# DEPARTMENT OF PLANNING

### SUBJECT: 78-96 ARNCLIFFE STREET AND 31-45 PRINCES HIGHWAY WOLLI CREEK - ROCKDALE LOCAL GOVERNMENT AREA

To determine a modification request for the 78-96 Arncliffe Street and 31-45 Princes Highway, Wolli Creek – Rockdale Local Government Area.

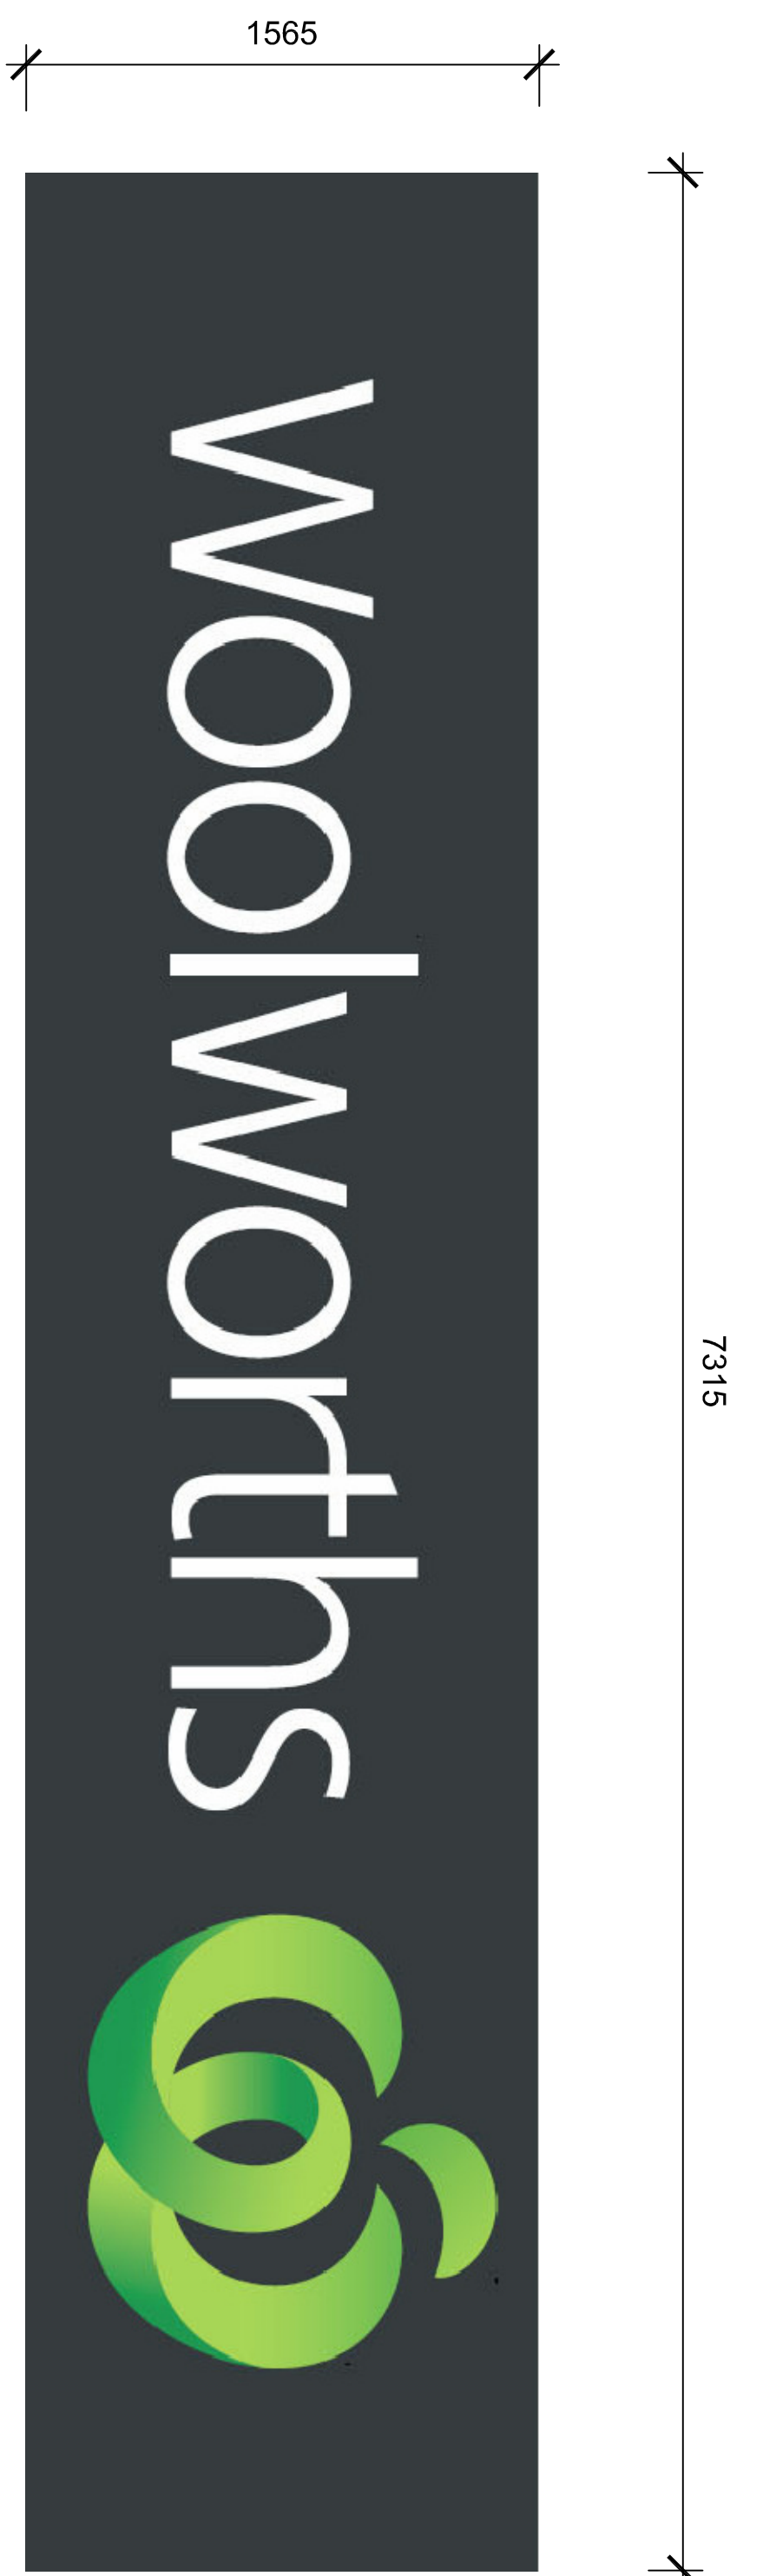
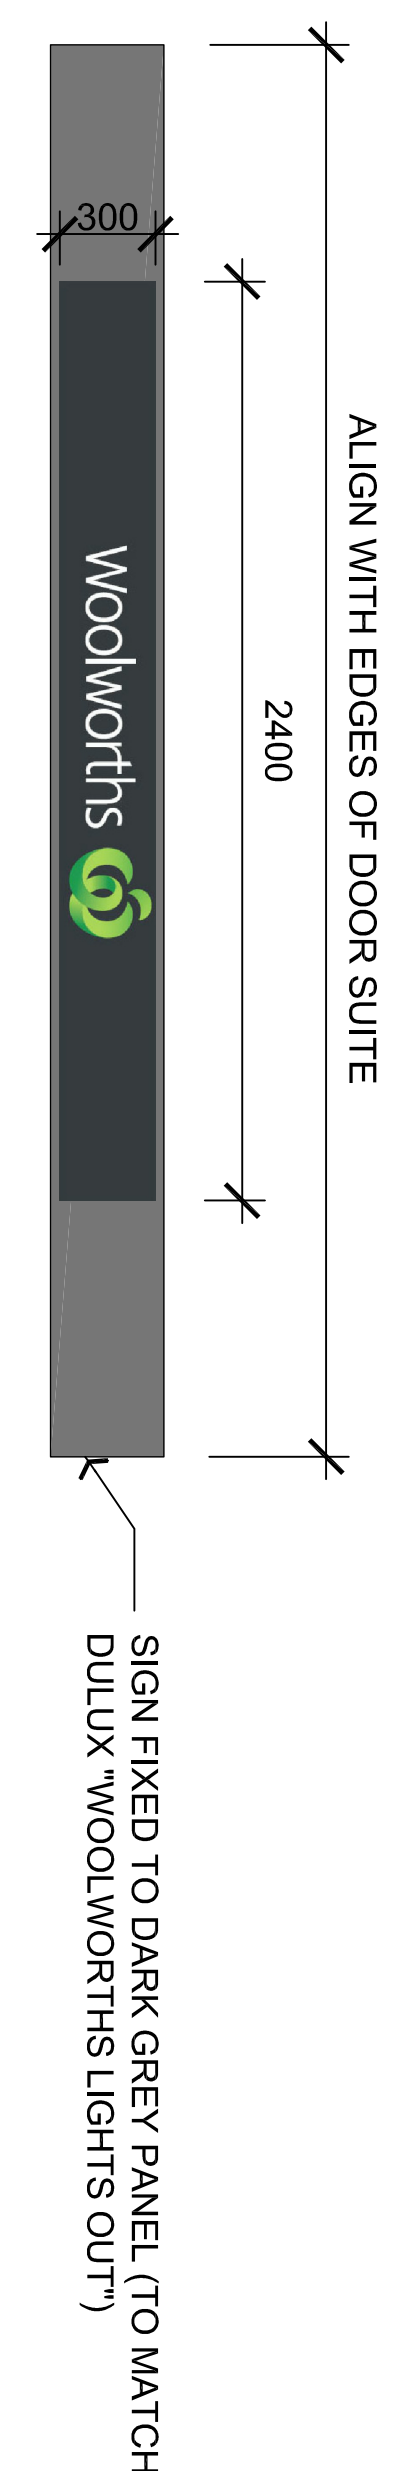
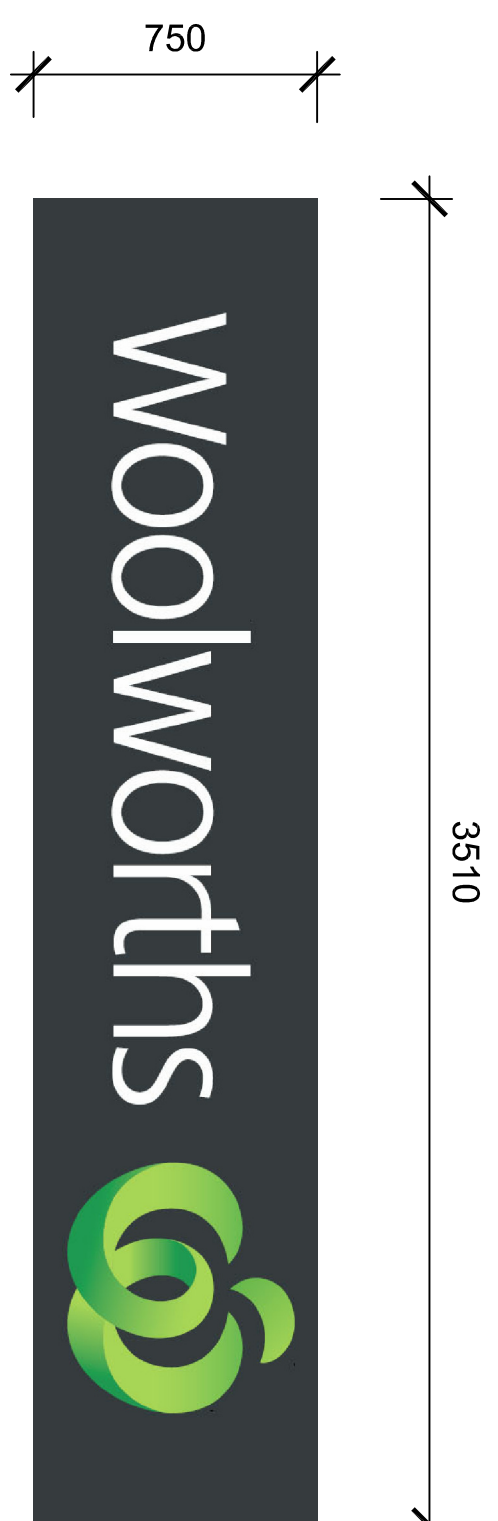
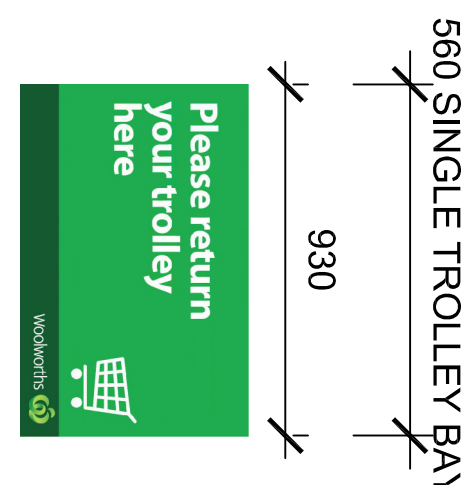
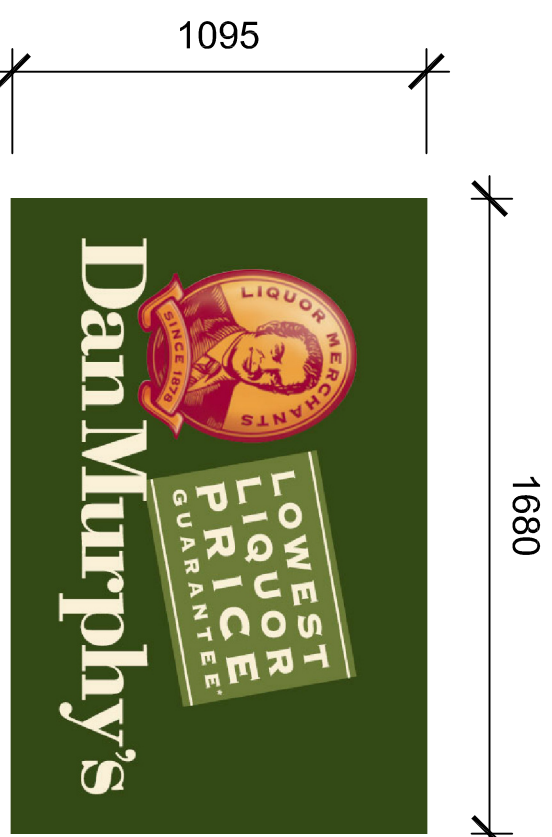
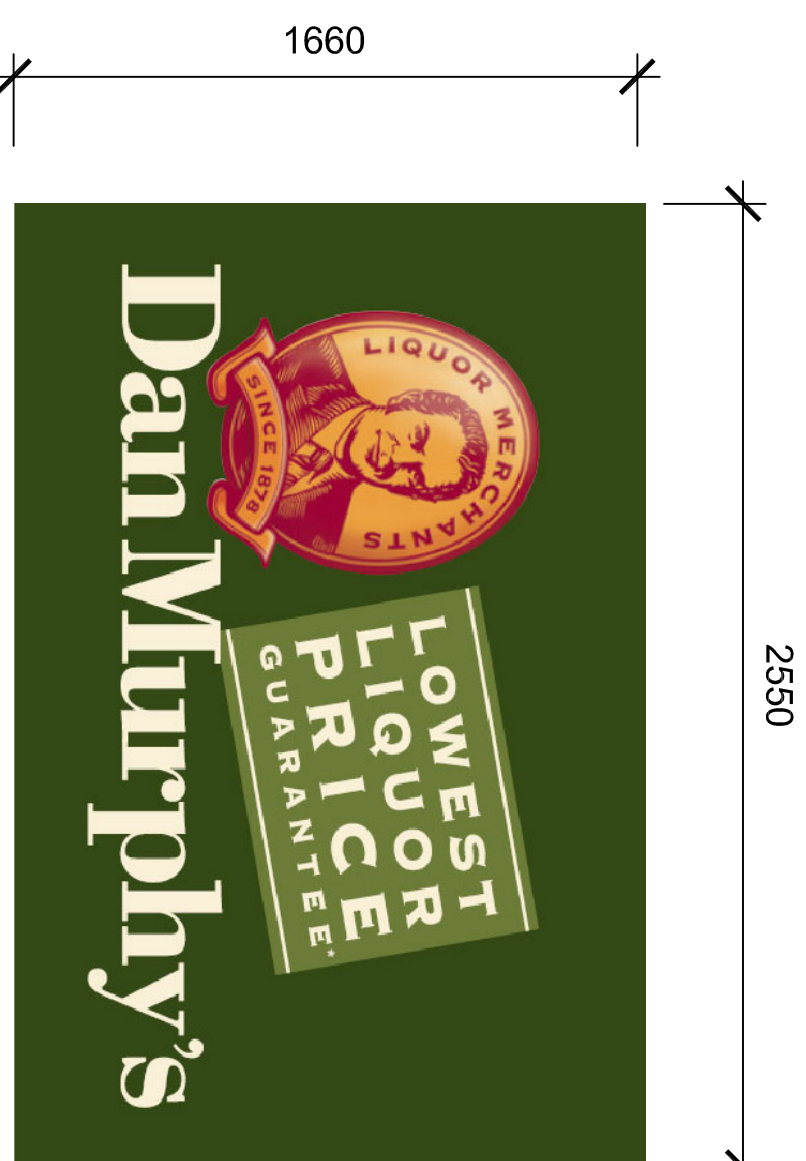
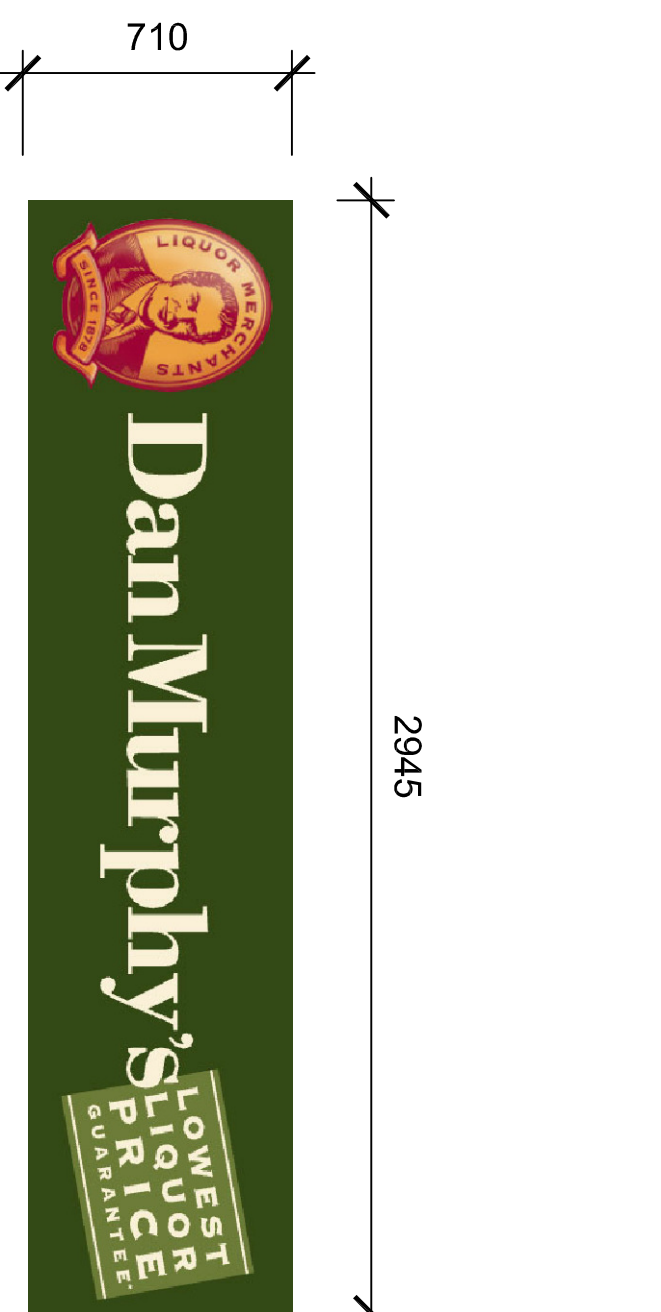
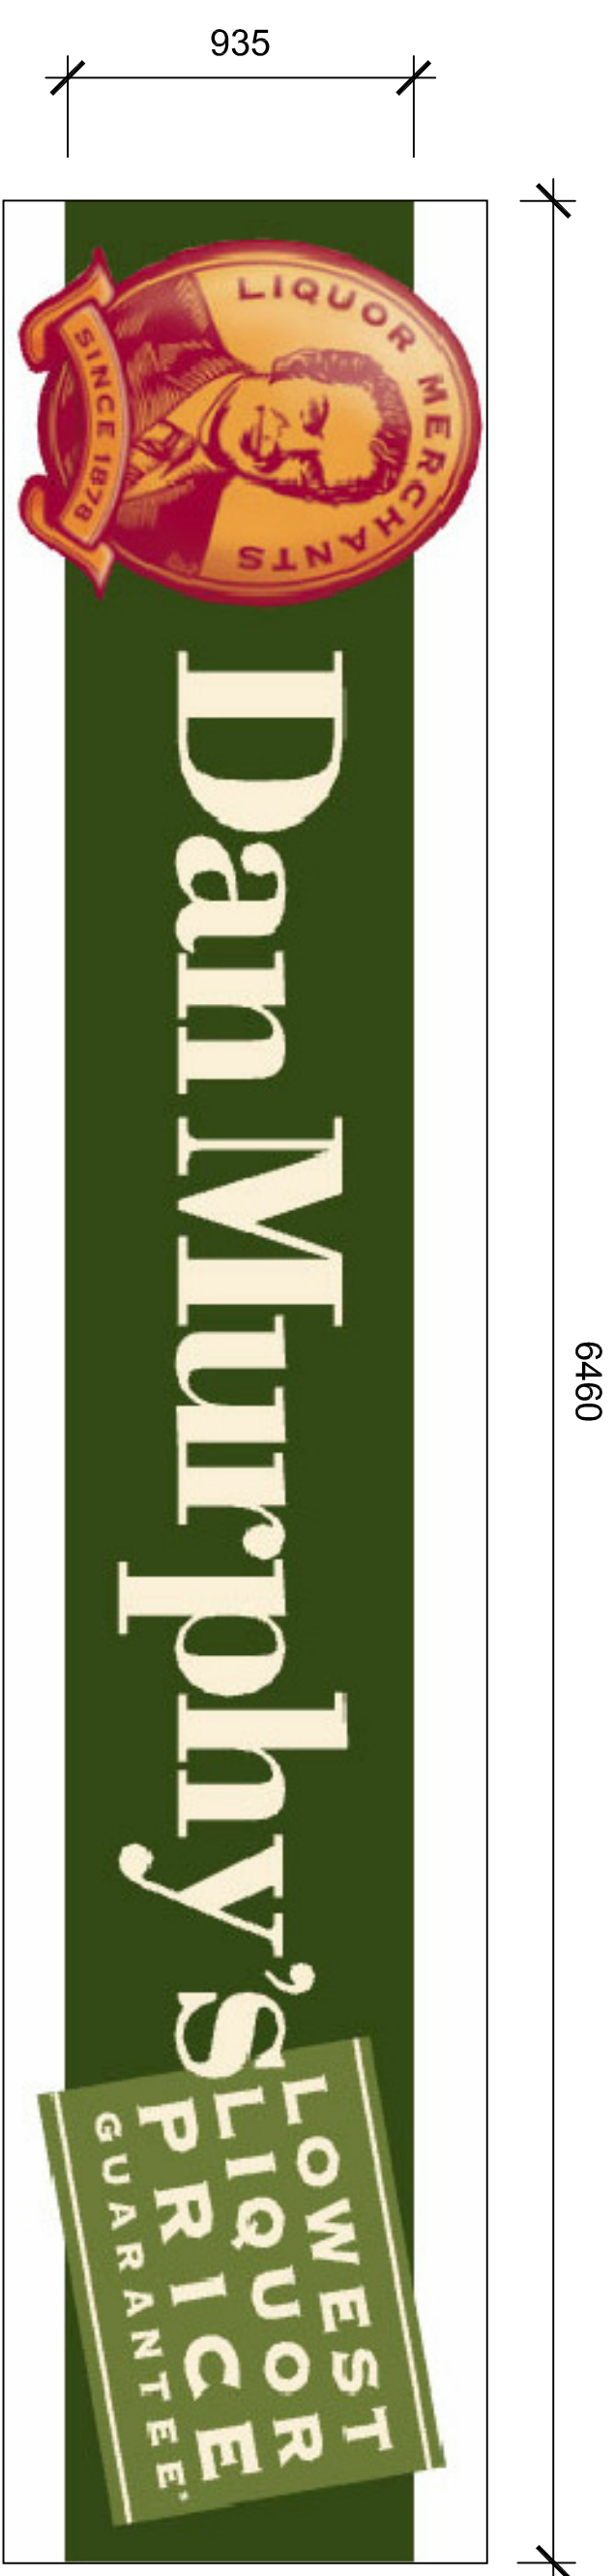
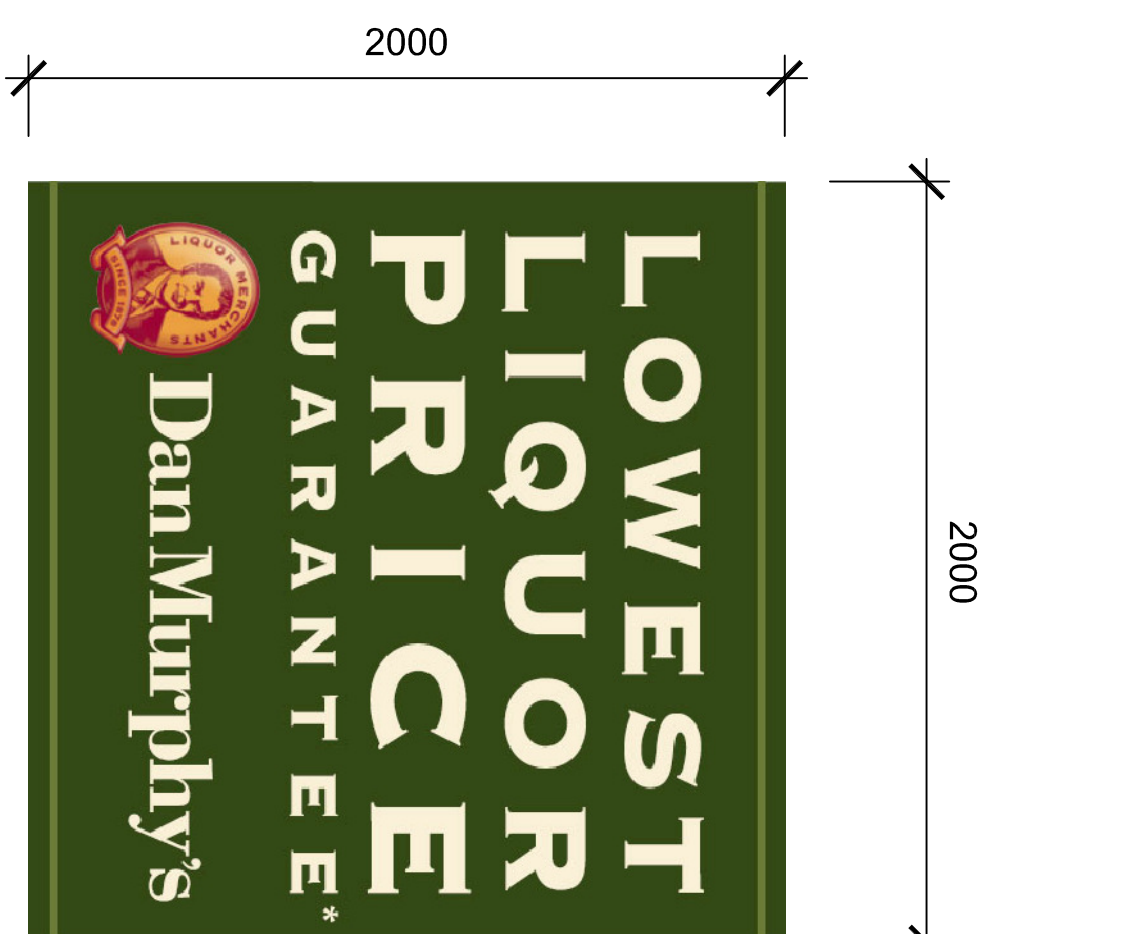
- Signage – The proposed signage should be should subject to a separate application to be determined by Council in accordance with condition B3.
- Notification – The application should be notified given the potential adverse impacts on adjoining residents as a result of the proposed extension of loading dock hours.

The modification request seeks inclusion of signage as part of the development approval. 15 signs are proposed relating to future occupation of the site. The signage plans provided are for "Woolworths" and "Dan Murphy's" tenancies.

Condition B3 of the approval required that signage and internal fitout of retail areas must be the subject of separate development applications to Council. The proponent fails to justify the need for approval of signage as part of the development by the Department and it is appropriate that the condition remain.
